REF: Maughanaclea Ltd. Case PAX04 324165

SID application for 14 No turbines at Maughanaclea etc.

Cumulative Context

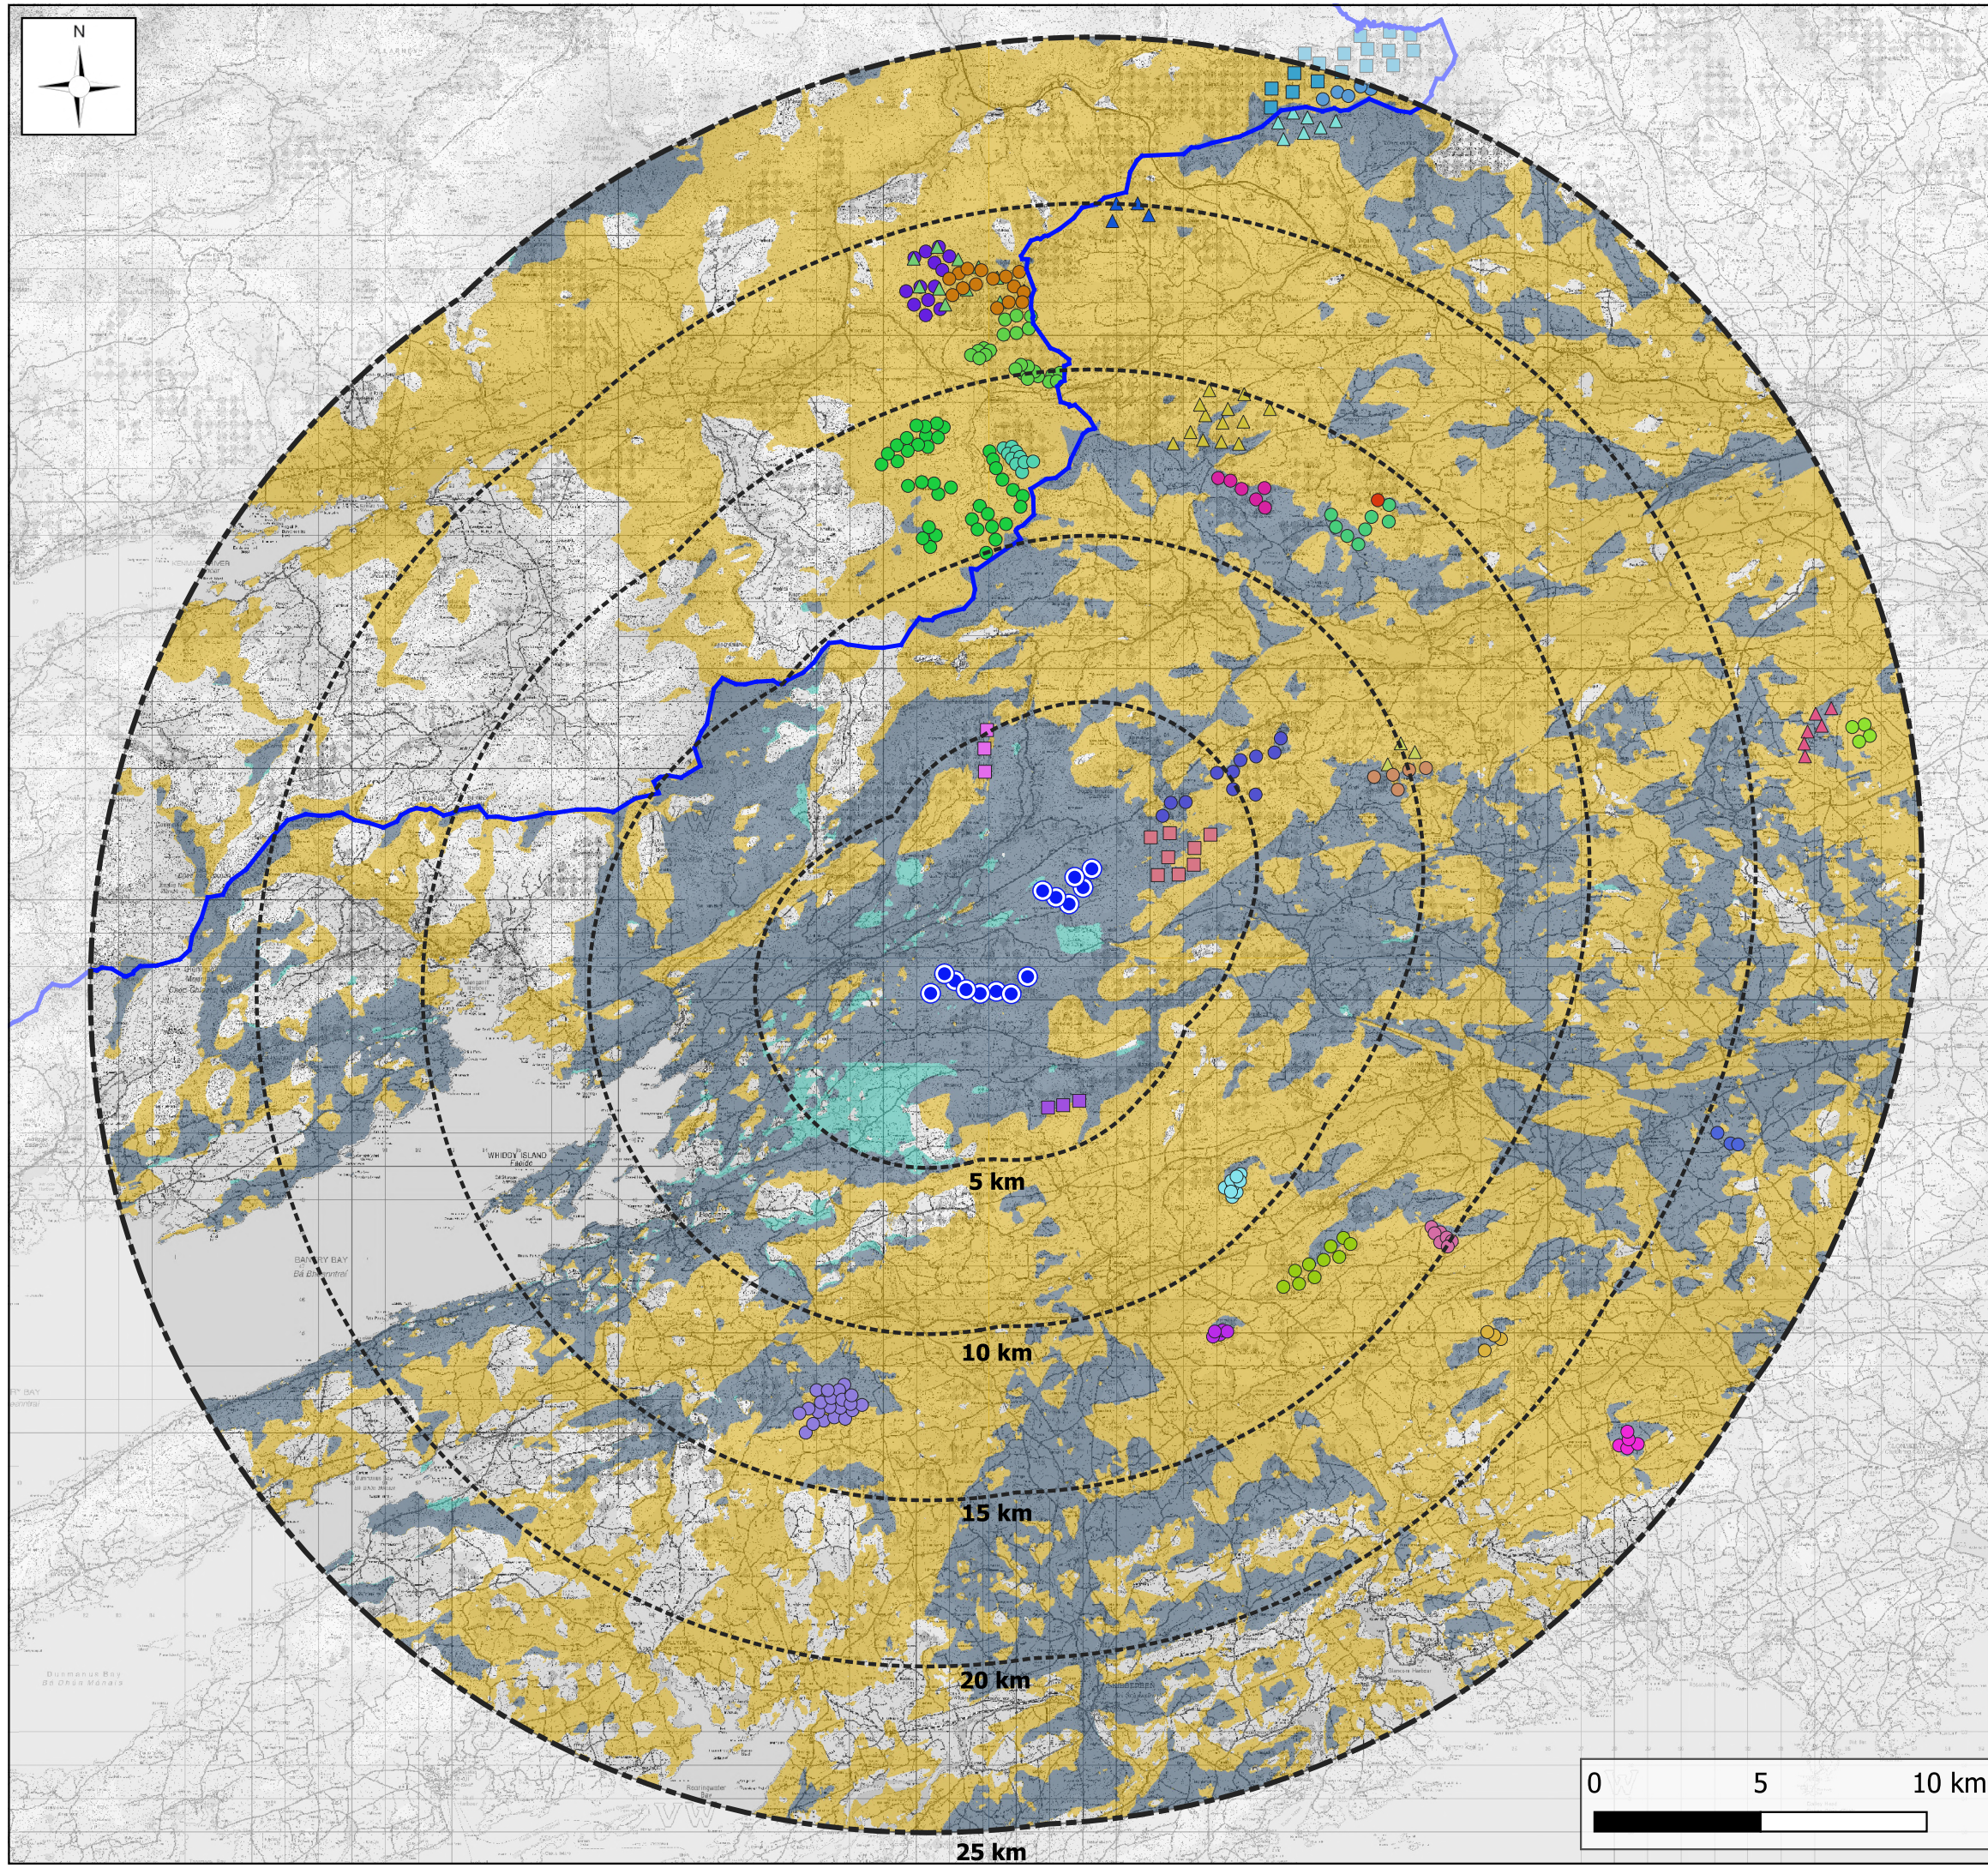
The above photos were taken at nearby Carrigerierk wind farm which show the amount of habitat that is lost and the scale of visual intrusion involved with these wind farms. There are just too many wind farms now in this part of West Cork, creating a huge cumulative visual impact. A list of wind farms in a 25km radius was provided in the inspectors report to inform ACP. However, even this list is incomplete and at least three wind farms have been omitted- Curraglass, within a 2km to the north, Derreenacrinnig immediately to the south and Ballingearry to the northeast.

Figure 13-18 Scenic Route 29 Route Screening Analysis and ZTV

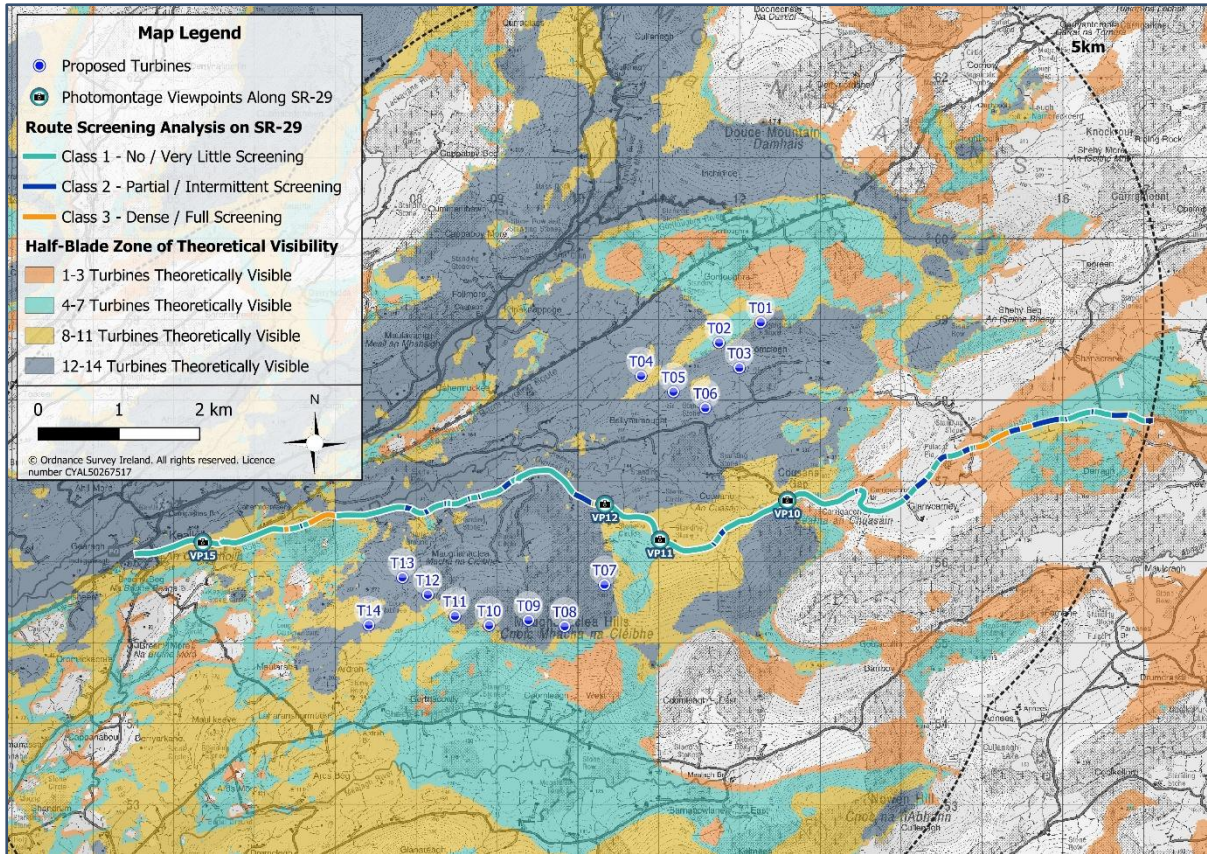
This application has the R585, scenic route S29 at its heart which is also an important entrance way to the Beara Peninsula and a popular section of the Wild Atlantic Way. Objectives GI 14-9, GI 14-13 and GI 14-14 in the current Cork CDP seeks to protect the character of those very special views and prospects obtainable from such scenic routes and to ensure that there are no adverse obstructions or degradation of such scenic views.

S29 is known not only for Shehy Mountain and the Cousane Gap but also for wide views over the Kealkill valley. The proposed wind farm would dominate views in all directions and completely alter the character and experience of this scenic route. This can be clearly seen in a number of the photomontages including numbers 8, 10, 11, 12, and 15. They give a clear impression of how dominated the eastern end of the Kealkill Valley, Shehy Mountain and the Cousane Gap would be by turbines, organised in a very incoherent and messy way. It would be reminiscent of the wind farm west of Drimoleague at Mount Kid, which the County Council is always holding up as an example of how NOT to site a wind farm.

Figure 14-20: National monuments and Preservation Orders within 10km study area.

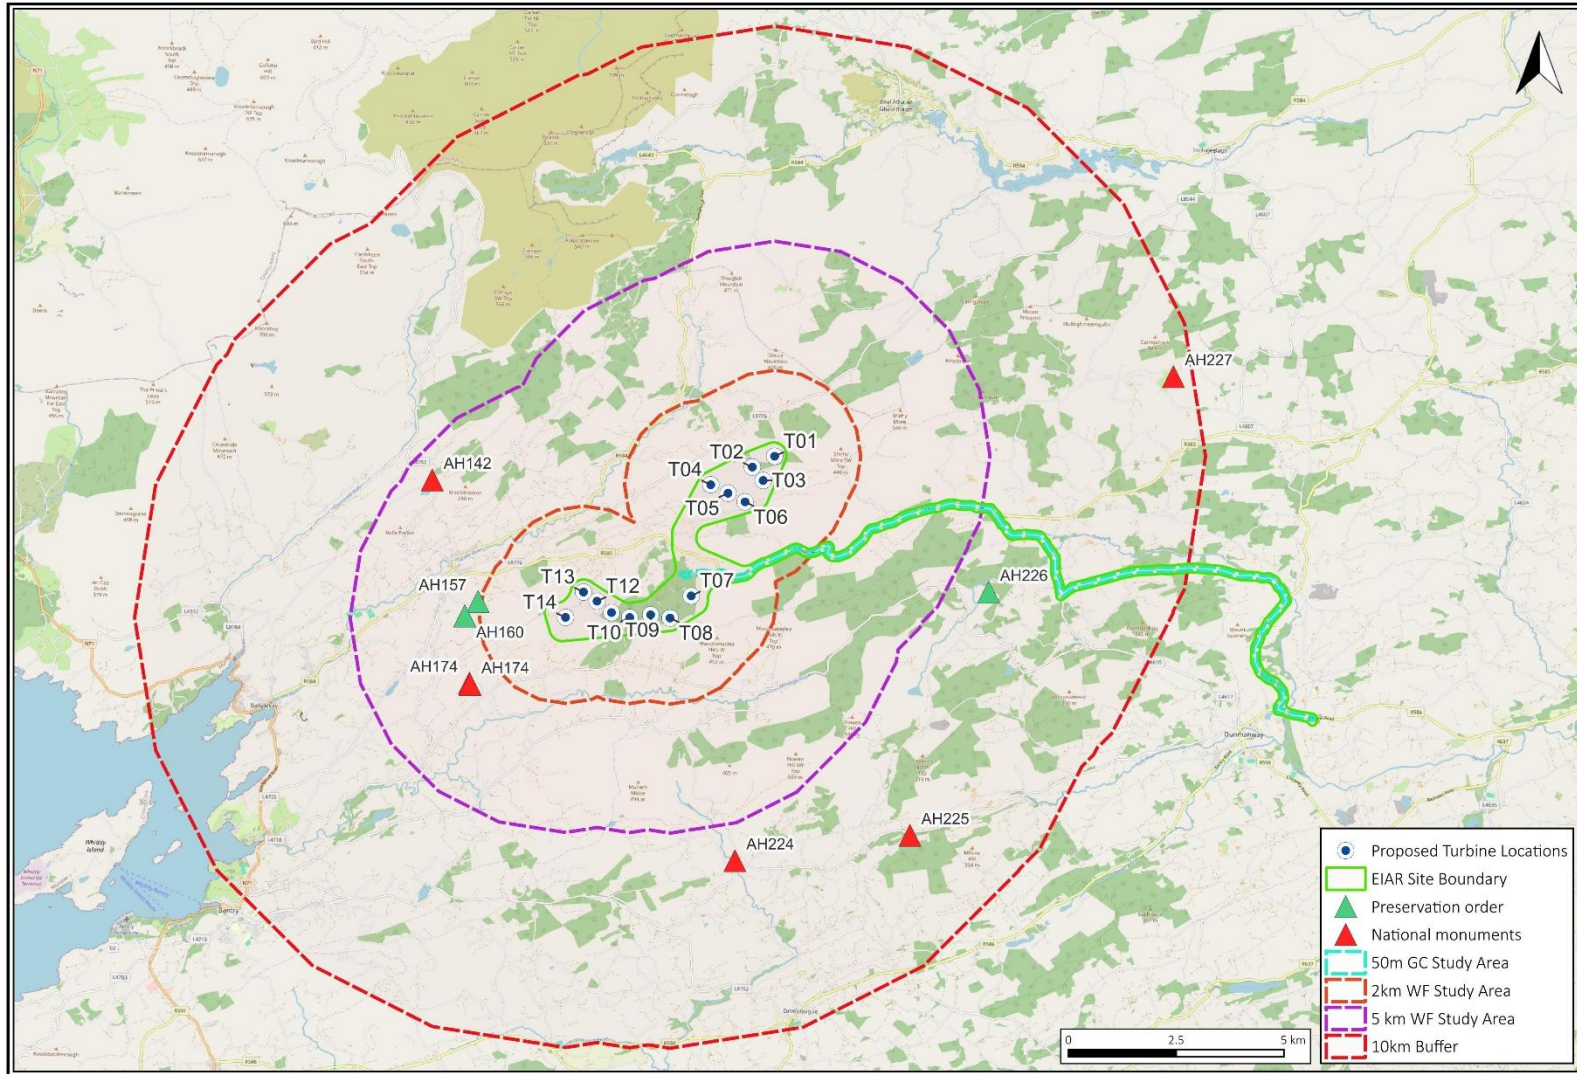
The views and outlook from such monuments, as well as the direct alignments from them, are very important and an integral part of their design and site location. Yet these have not been specifically discussed or assessed to any degree within the EIAR. Kealkill stone circle- a National Monument- will be most clearly affected by this proposed development as it is open to the public and is a magnificently sited monument with far reaching views from it. It is part of a Bronze Age ritual complex, including a stone pair and radial stone cairn, and gives a clear impression of the importance of these uplands to the people of the Bronze Age. As such it is a very popular visitor attraction with a unique atmosphere. The alignment from the stone pair as well as the circle would be especially dominated by the proposed wind farm. Photomontage 4 gives an impression of the considerable visual impact this development would have on the stone circle and but still does not include the additional turbines, now approved, close-by to the north in Cappaboy.
